Stormwater Best Management Practices Inspection and Maintenance Plan (IM Plan)

Lot 11 Rolling Thunder Business Park

PCD File No.: PPR-21-024

ROLLING THUNDER BUSINESS PARK
DRAINAGE PLAN
N.T.S.

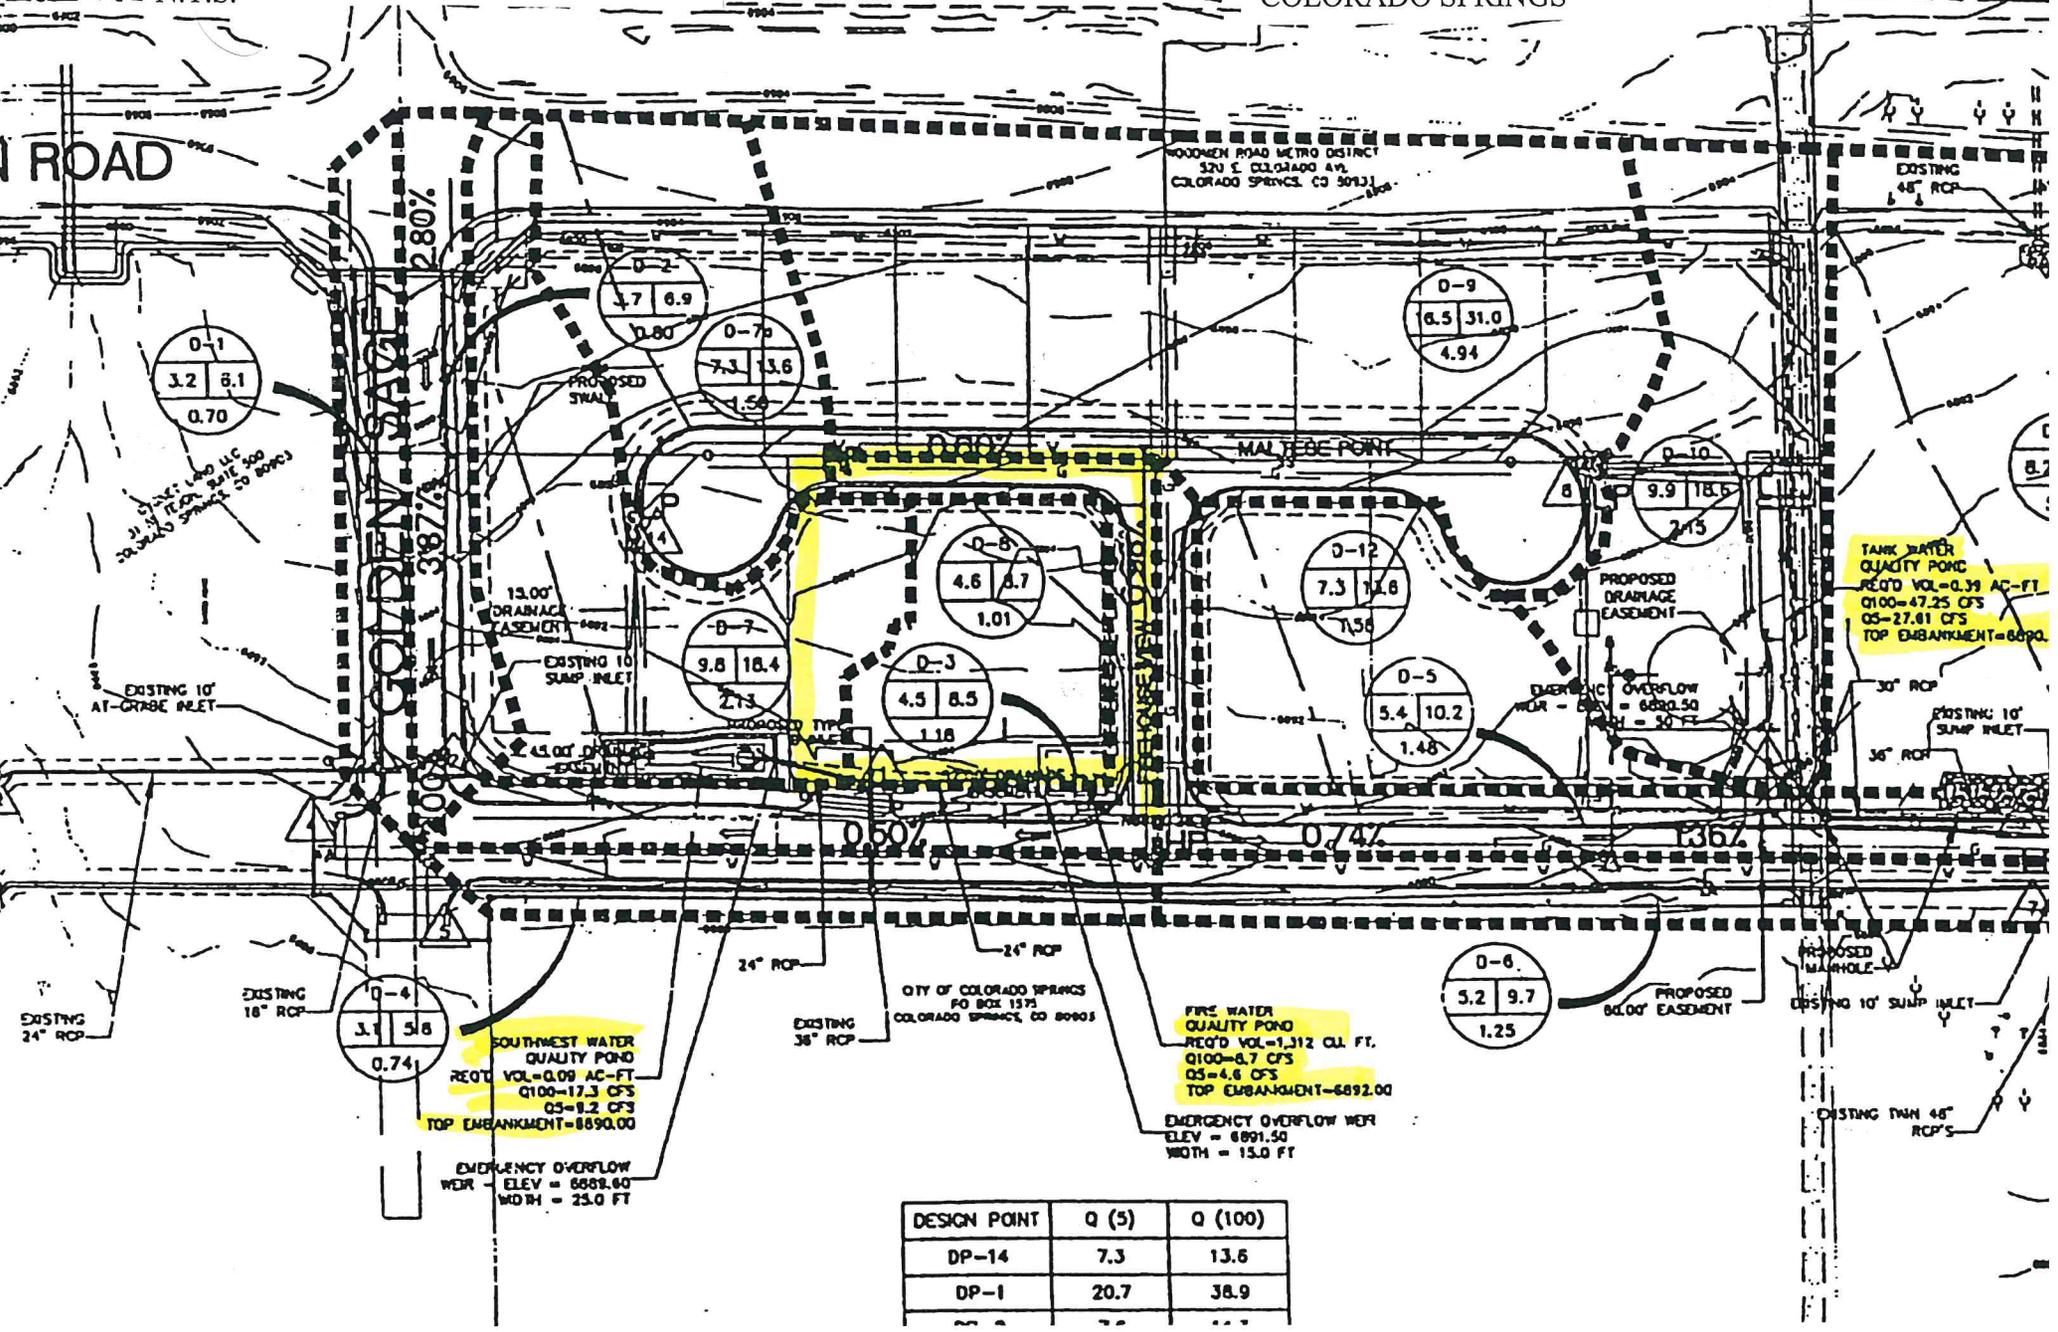
This is not accurate. The SW does not leave the WQ pond and enter the pond to the west of the Site.
